Great Crested Newt Review

Project: M54 to M5 Link Road: Allow's Land Holdings

Technical Briefing Note TN02: Review of 2020 Great Crested Newt Data

Date: 19 October 2020

Drawing Title  
FIGURE 8.28:  
GREAT CRESTED NEWT  
BASELINE DESK STUDY RESULT

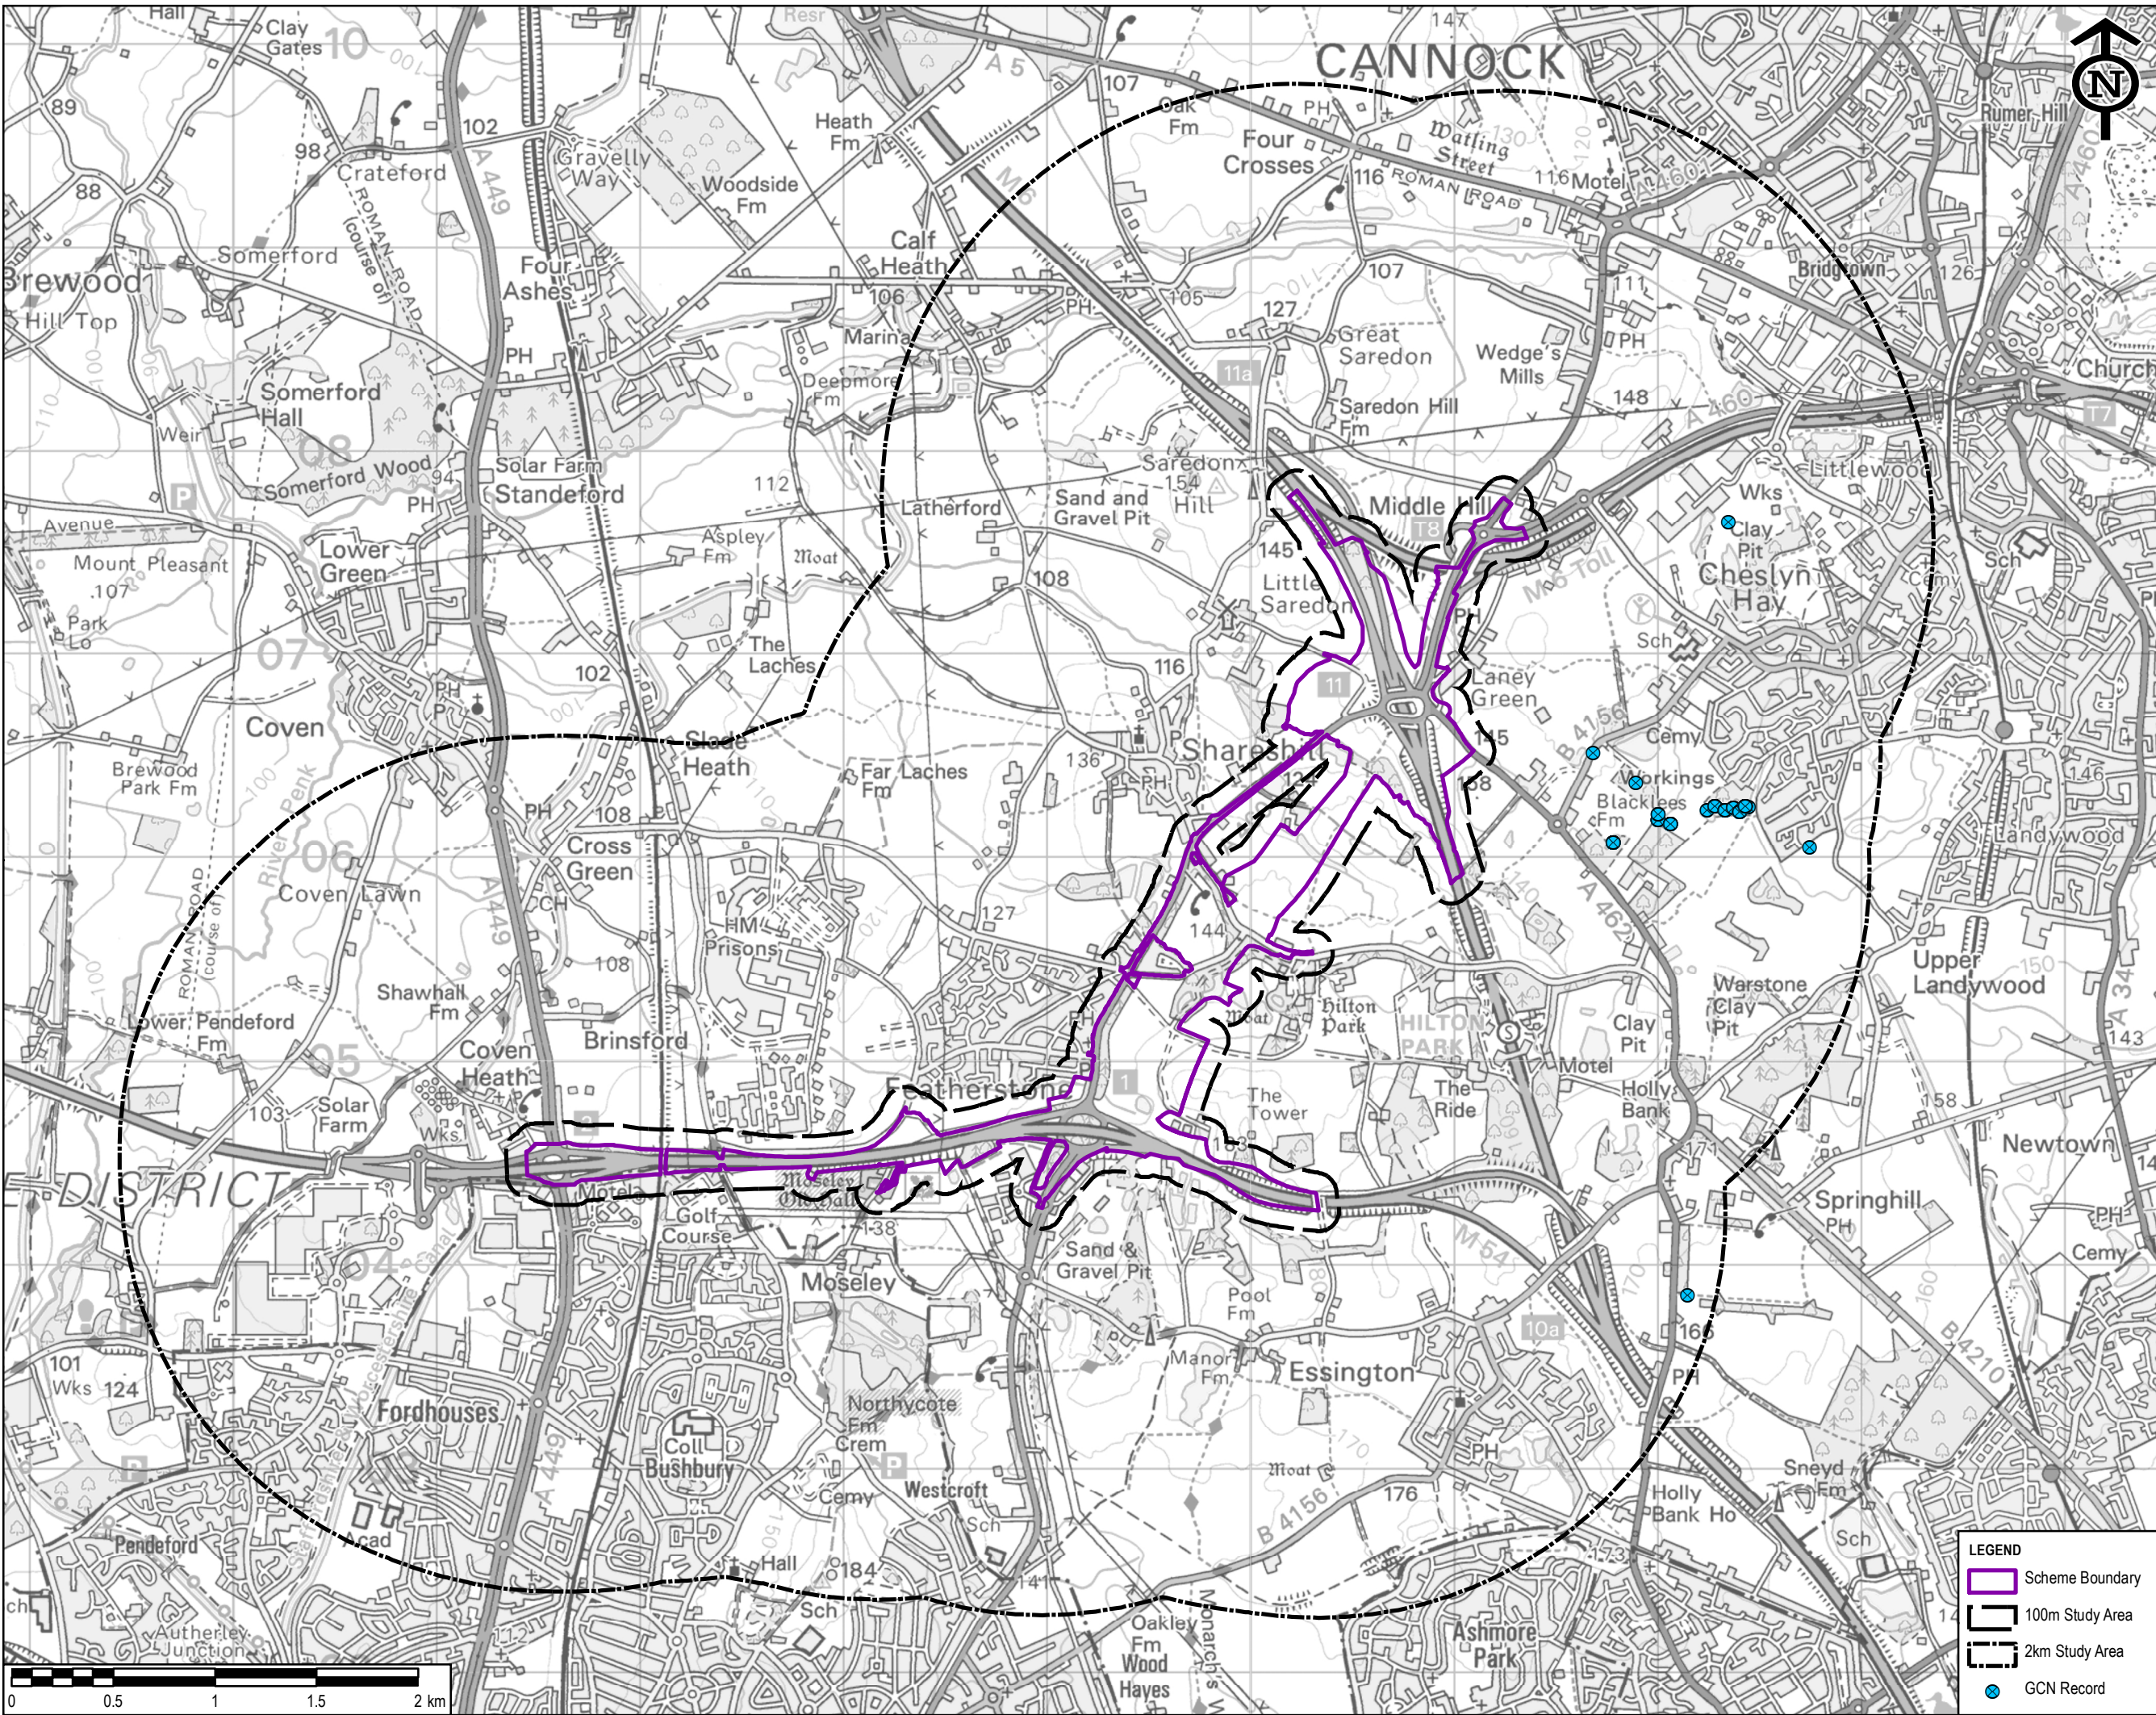
- 3.4.1 Figures 8.28 and 8.29 of the ES, plus the results obtained through the 2020 survey, show that historic, and current, known presence of Great Crested Newt is greatest to the east of the

proposed scheme. However, compensatory ‘ecological ponds’ will be created to the west of the scheme.

- 3.7.1 All background records for the species (Figure 8.28 of the ES) and ponds confirmed to support GCN (confirmed through eDNA surveys for the scheme – see ES Figure 8.29) are located to the east of the proposed scheme. As such, the appropriateness and effectiveness of creating compensatory habitat for this species to the west of the scheme is in question. If the location of compensatory ponds is inappropriate, then the current habitat creation proposals for land within 500m of these ponds (designed to benefit the species) should also be reviewed alongside proposed pond locations. This must all be based on up-to-date survey information⁵.

3.4.3 It is still recommended that the siting of mitigation is re-visited and this re-located to the east of the scheme.

Drawing Title
**FIGURE 8.29:
GREAT CRESTED NEWT
BASELINE SURVEY RESULTS**

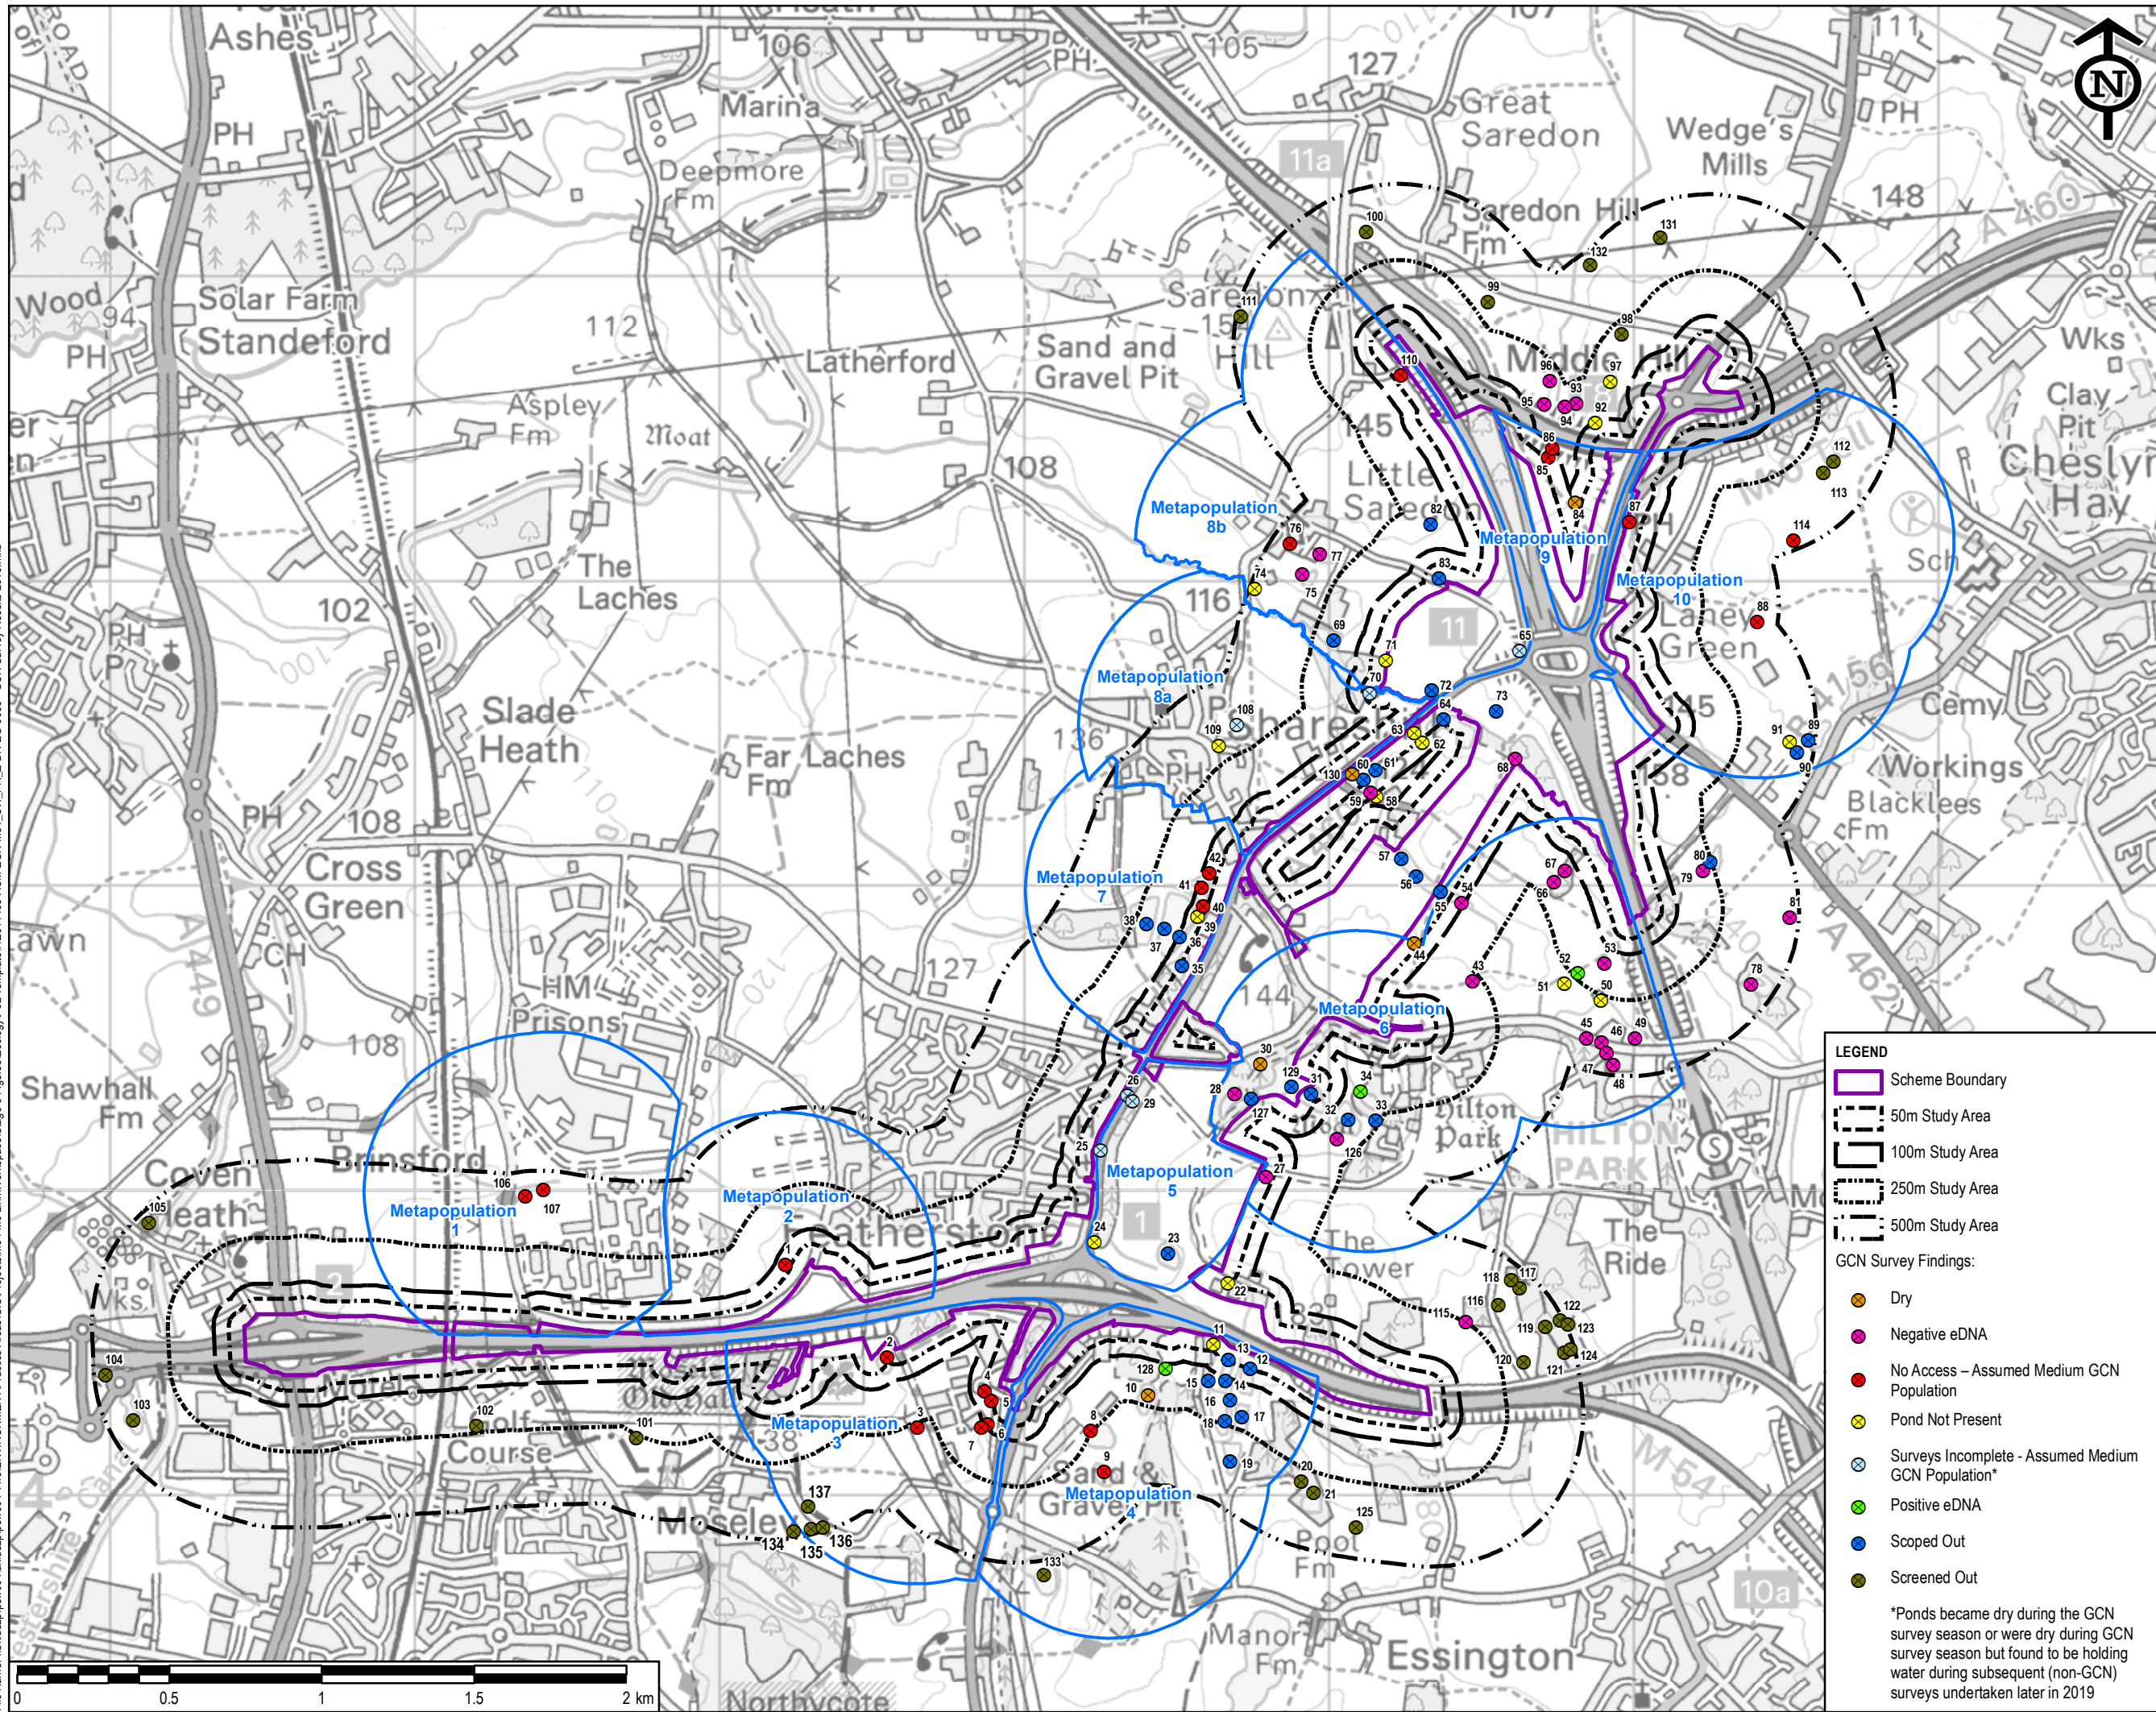
- 3.7.2 The Environmental Statement describes Ecology Ponds EP05 and EP06 as being provided for ‘assumed’ metapopulation 5a (although only metapopulation ‘5’ is shown on Figure 8.29). However, surveys in 2020 have confirmed that this ‘assumed’ metapopulation does not exist. As such, there is no apparent need to site EP05 and EP06 in this location.
